WEST SUSSEX COUNTY COUNCIL CONSULTATION

TO:	Arun District Council FAO:Mr S Davis
FROM:	WSCC - Highways Authority
DATE:	29 July 2019
LOCATION:	Rear of Inglenook Hotel 253-255 Pagham Road Bognor Regis PO21 3QB
SUBJECT:	P/58/19/PL Erection of 9 No. dwellings with associated access, parking, cycle & refuse storage & landscape design. This application is a Departure from the Development Plan & may affect the setting of a listed buiding.
DATE OF SITE VISIT:	31/07/2019
RECOMMENDATION:	More Information
S106 CONTRIBUTION TOTAL:	£ See below for breakdown.

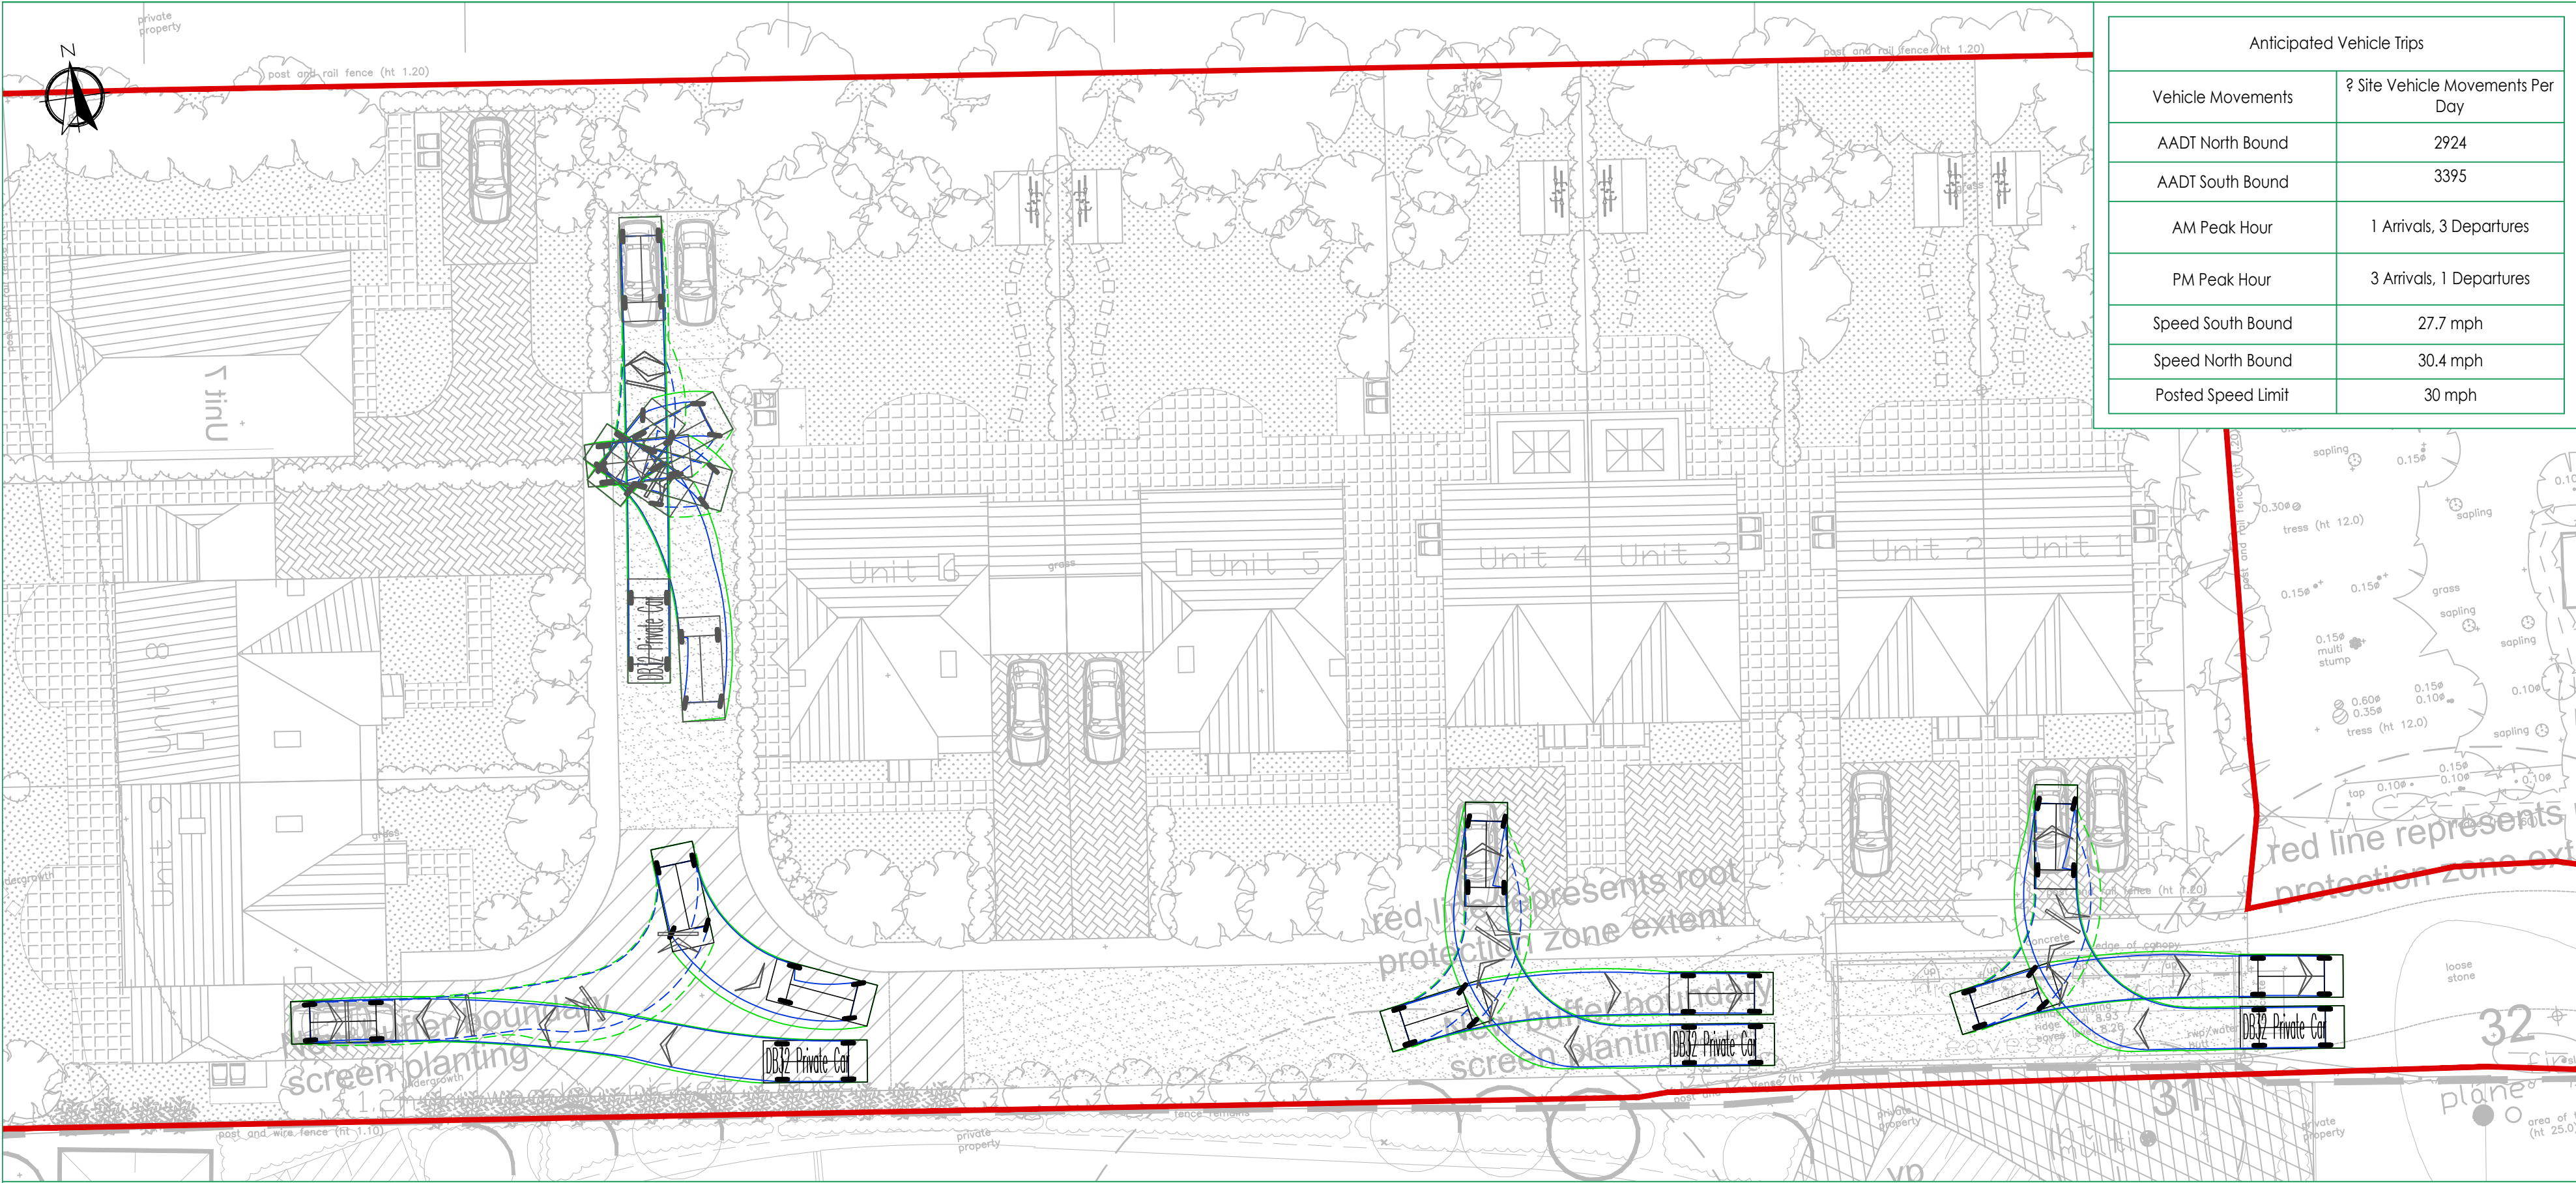
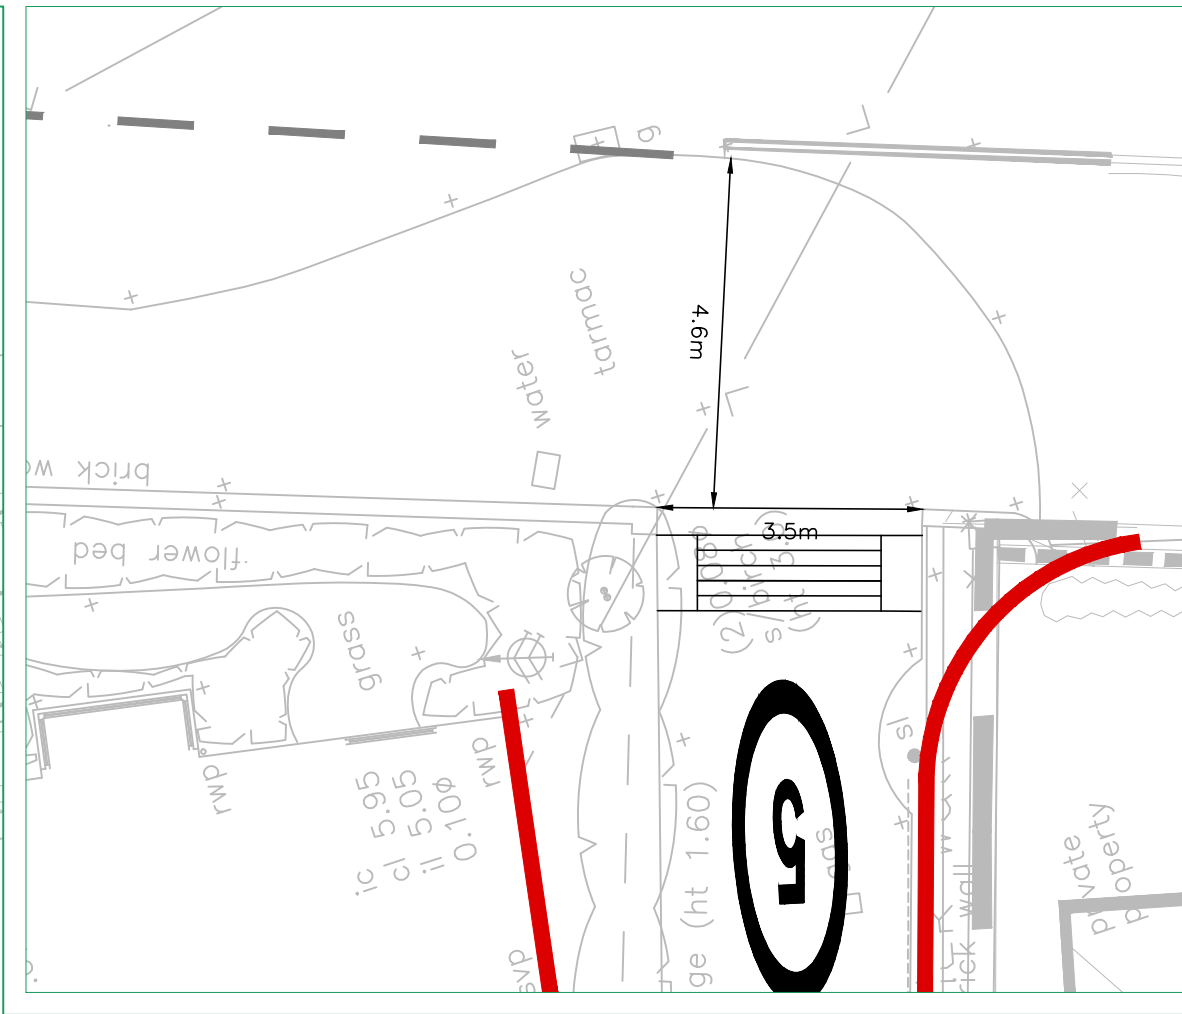
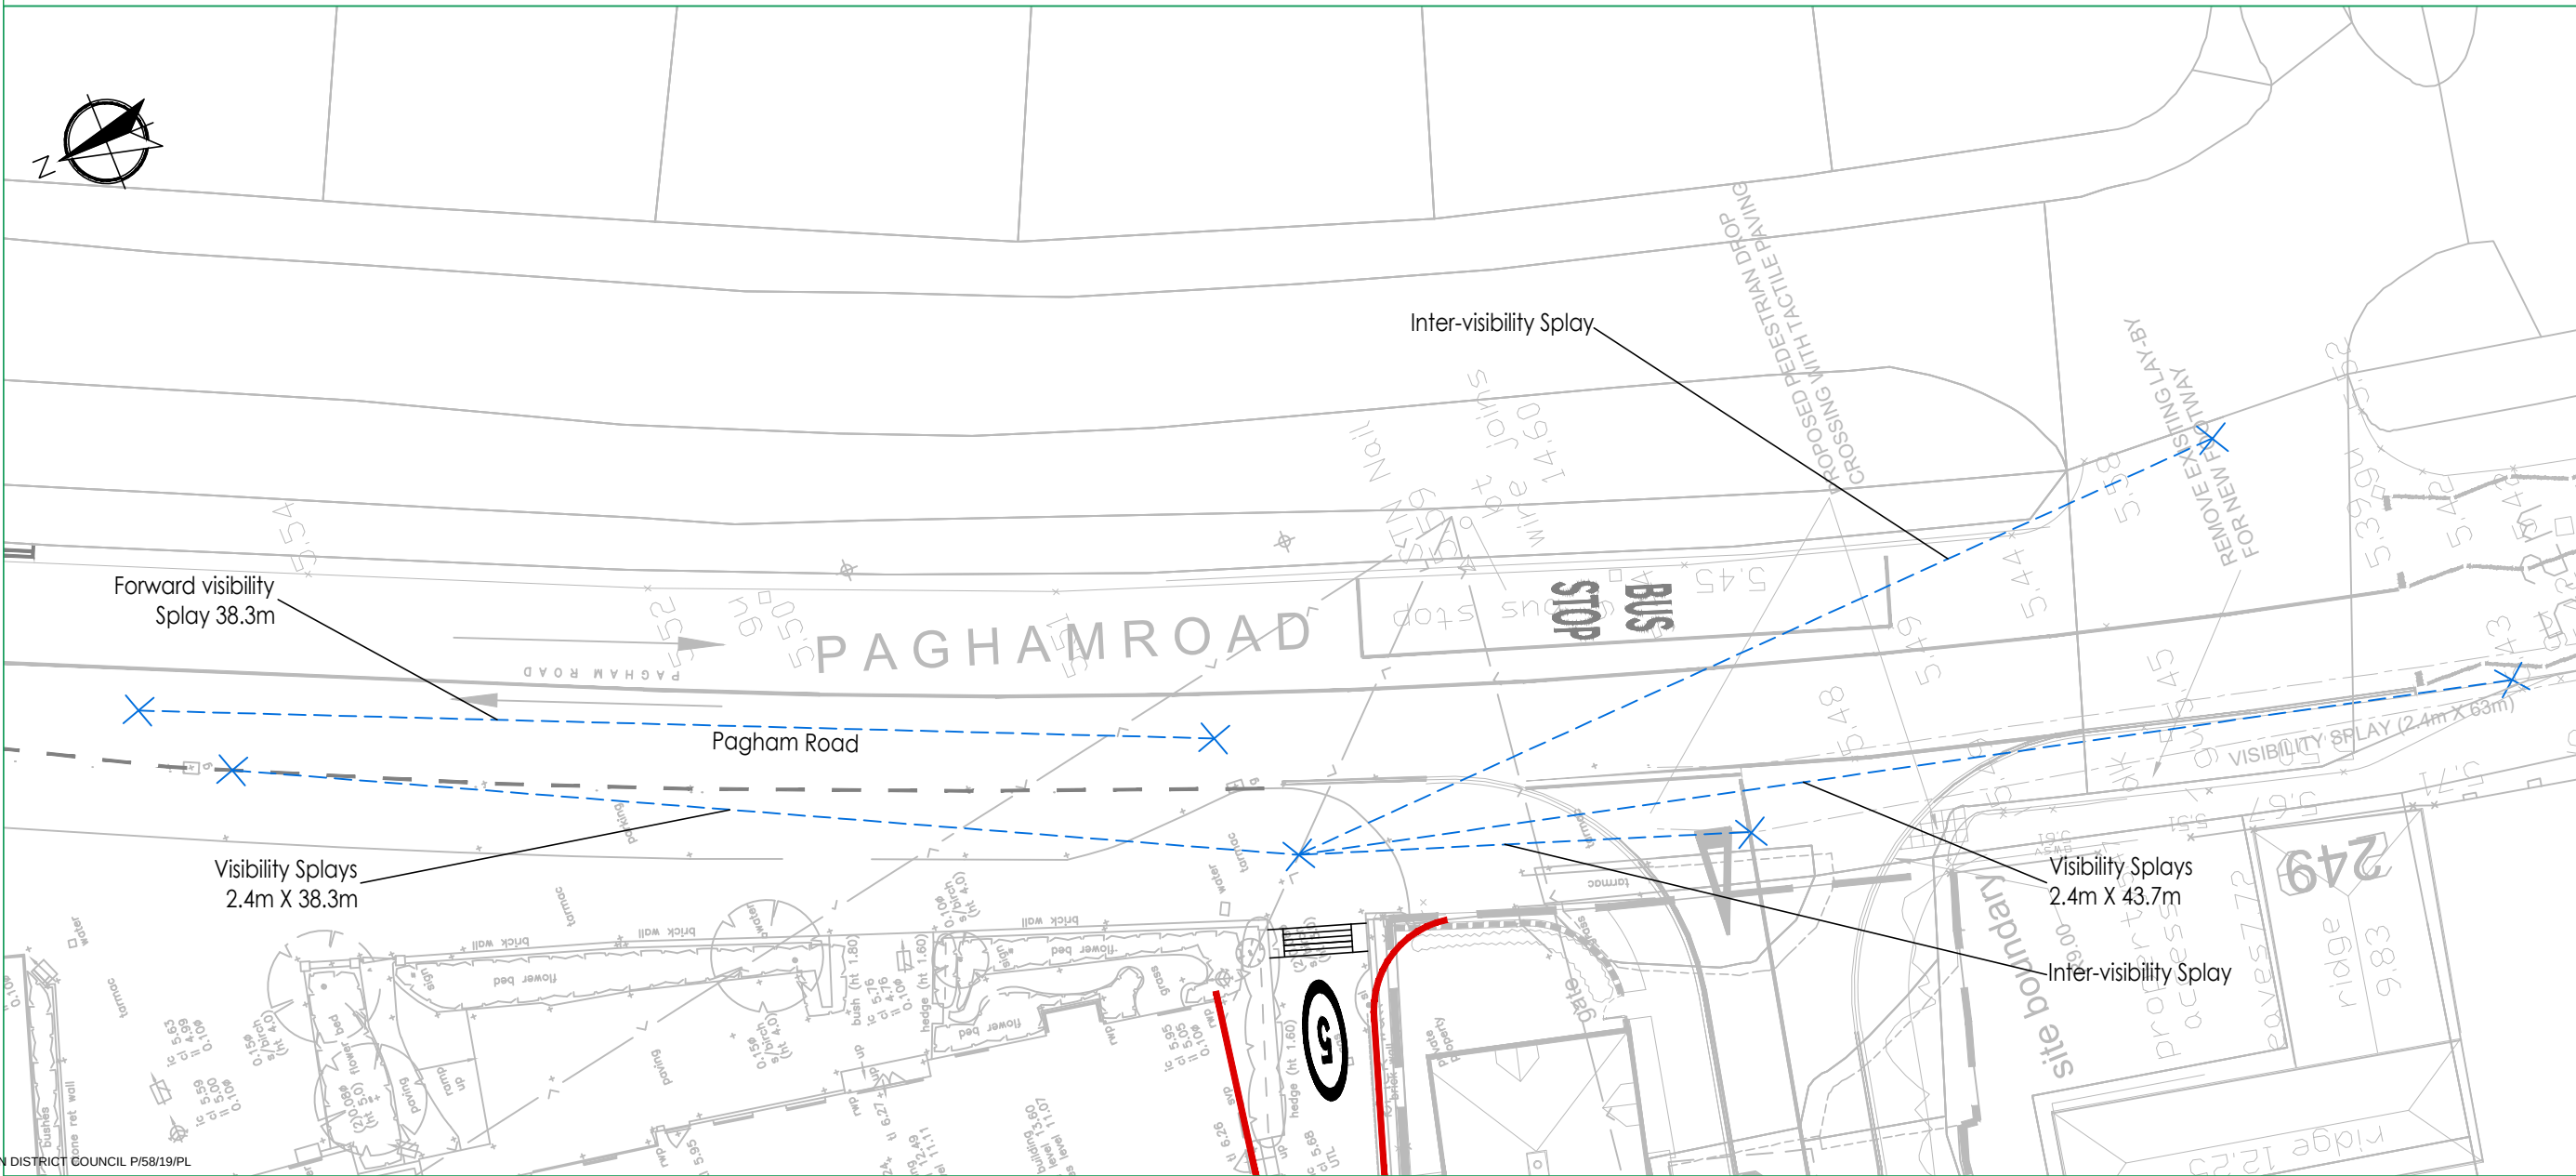
I have consulted the Area Highway Manager regarding the proposed signage and can advise that the Pedestrian in Carriageway sign is not required.
